Our Case Number: ABP-314724-22

Re: Railway (Metrolink - Estuary to Charlemont via Dublin Airport) Order [2022]
Metrolink. Estuary through Swords, Dublin Airport, Ballymun, Glasnevin and City Centre to
Charlemont, Co. Dublin

Observation on SID: Railway (Metrolink-Estuary to Charlemont via Dublin Airport) Order 2022 (ABP-314724-22)

MATER STATION

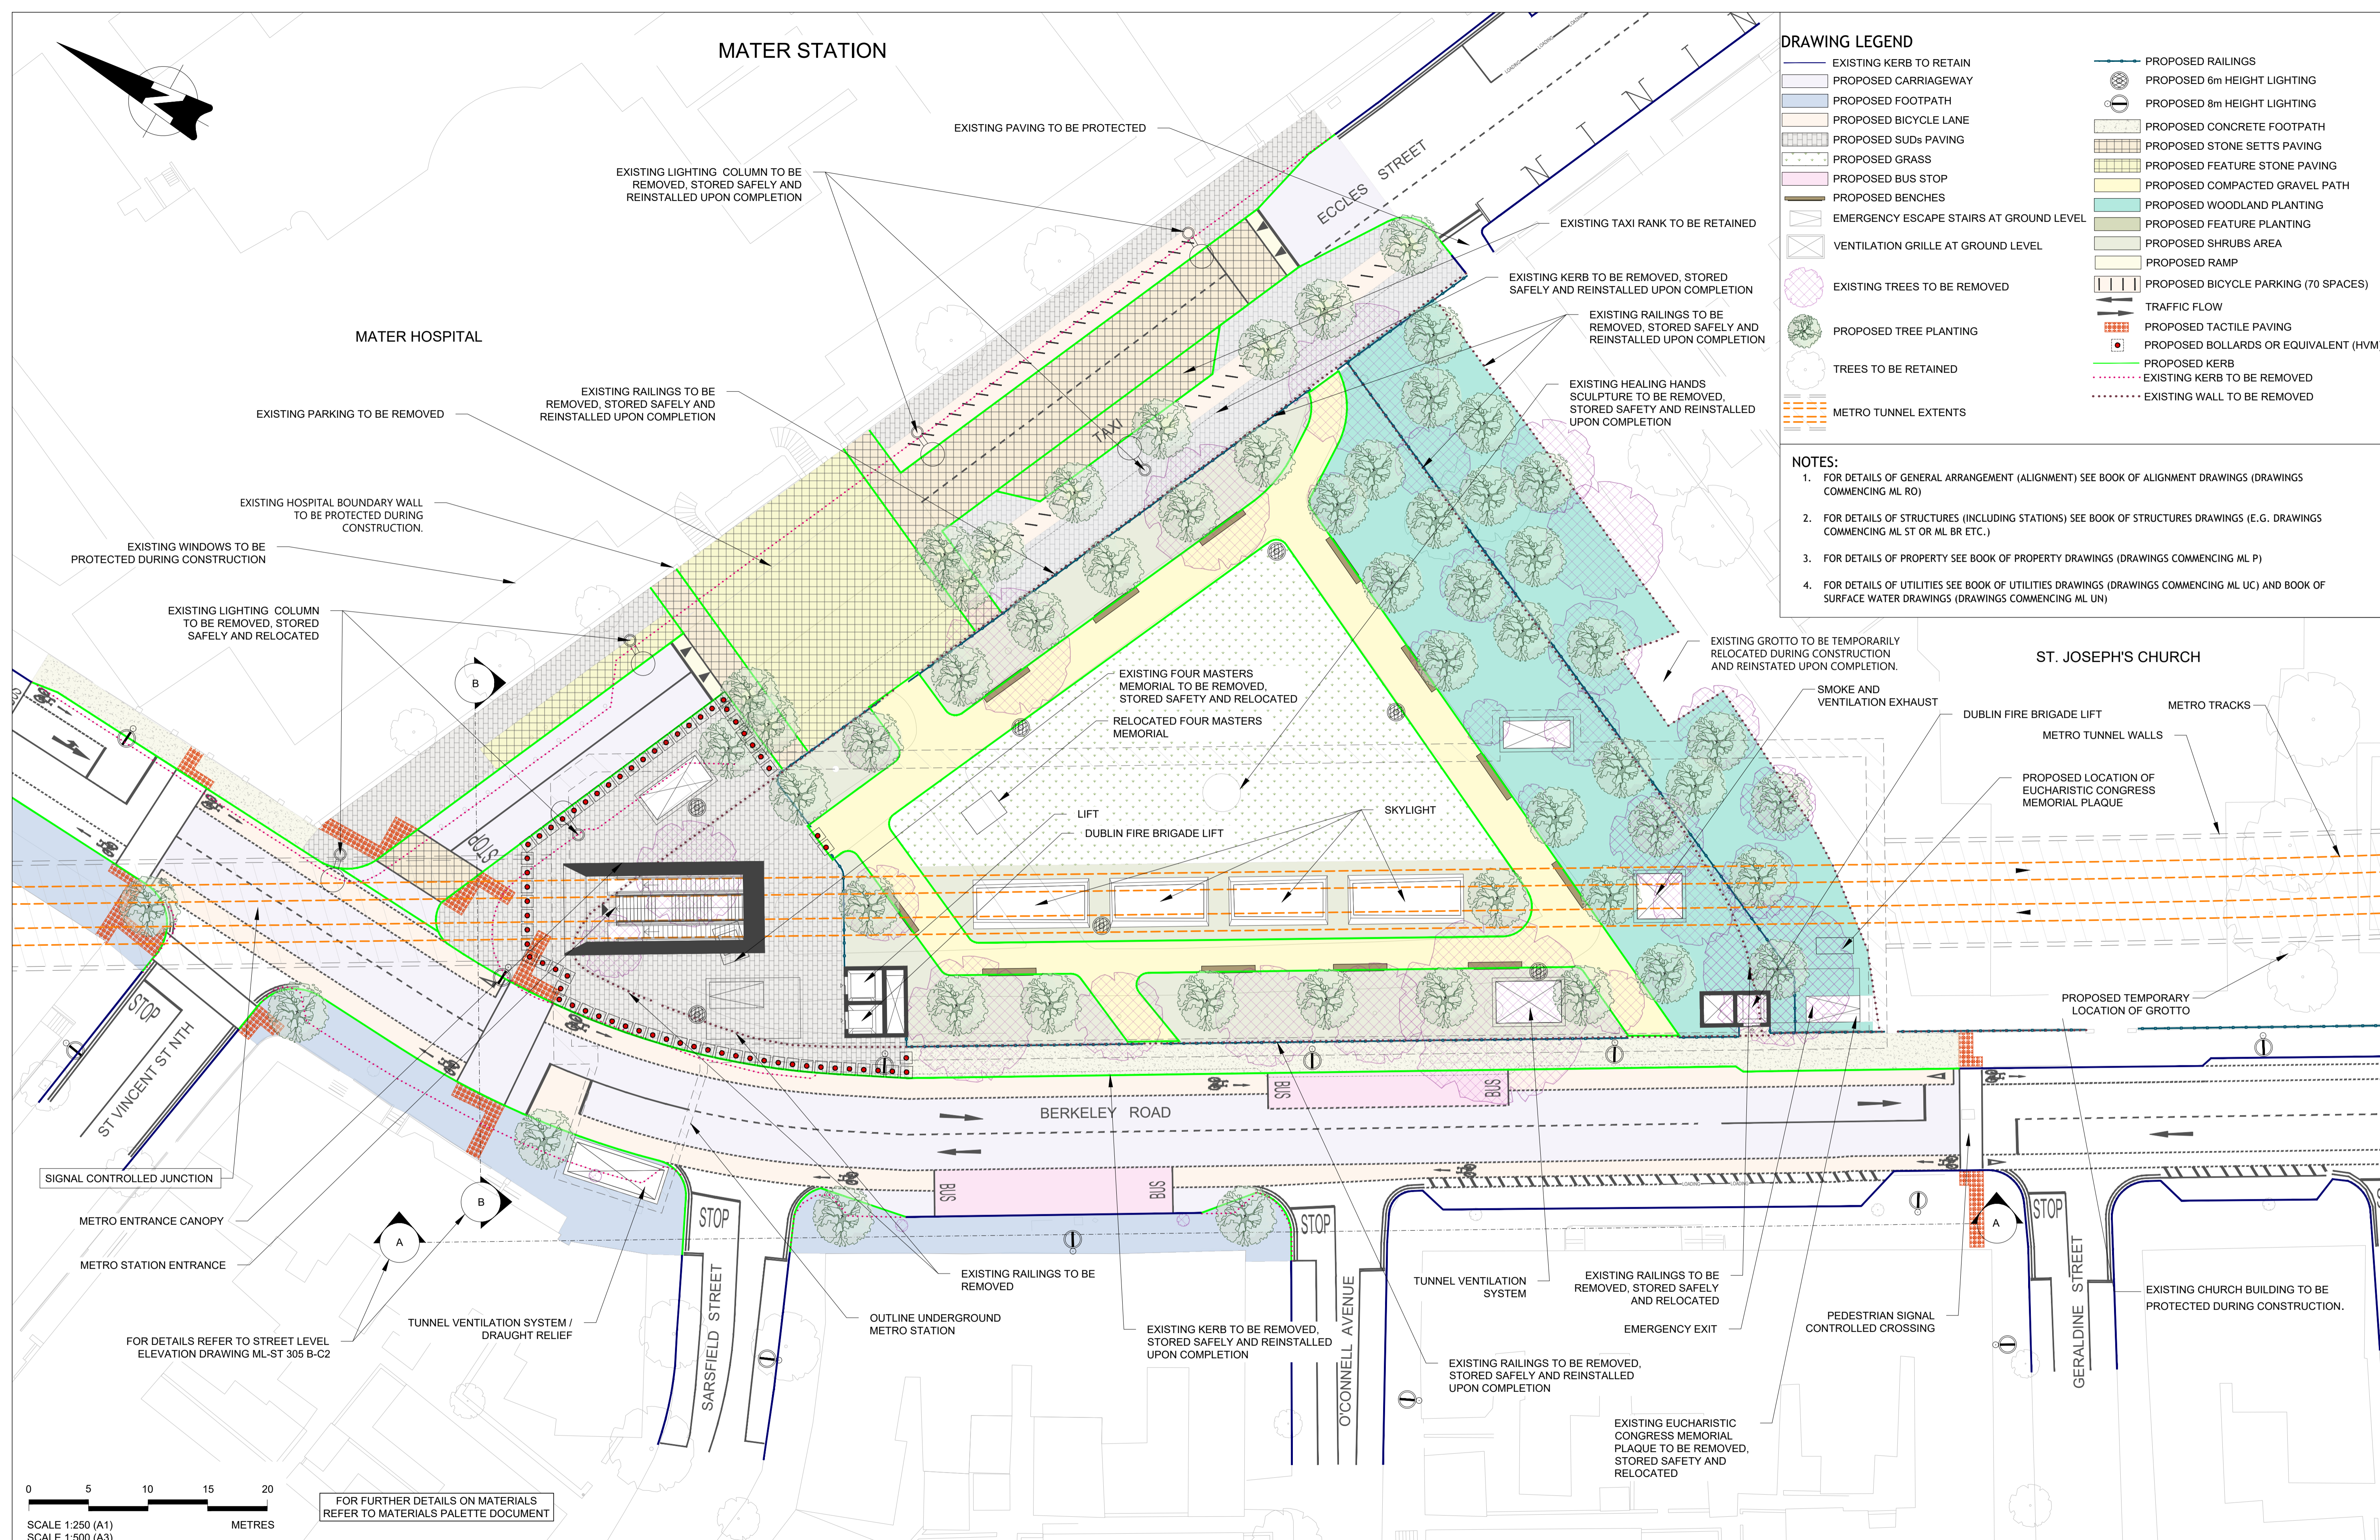
Our home is located directly opposite the Mater Station. The construction site will be immediately outside our house during construction of the western vent shaft during Stages 2, 3 and 8 of the Construction Sequence). We sought clarification on the location of this secondary site boundary both prior to and during the Oral Hearing. However, the information provided to us by TII at the Oral Hearing – which was that the site boundary is located at the kerb – appears to be incorrect. Information provided on Day 19 in the AIA Drawings p. 100 shows the site construction boundary meeting our house boundary (located at the red cross).

In light of the new documentation and the emphasis on numbers 20-21, there is no indication that sufficient mitigation measures are in place for No. 19 Berkeley Road, the residential property closest to the site works. We also note that there is no reference to No. 18 although that is part residential. As a remedy, we therefore ask that

1. TII to outline security provisions and impact on access to No. 19, including access to the street directly outside the property turning both left and right from the front gate.
2. TII review all relevant documents and maps and confirm a clear, definitive boundary for the western vent shaft site hoarding.
3. TII review any and all data and information provided on the construction and operational impact of the project to ensure that it is applicable to No. 19 rather than any other property on the street.
4. Following the review at (3) above, TII confirm that all possible and relevant mitigation measures will be implemented and provide a list of same.

5. Redesign of fire brigade lifts which - as currently designed and located – block views down Berkely Road including of the station entrance itself, the Mater and St Joseph’s Church.
6. Minimise impact of the station entrance by reducing its size and reducing the visual impact by narrowing the frame.
7. Increase planting in the final design which currently includes extensive paving
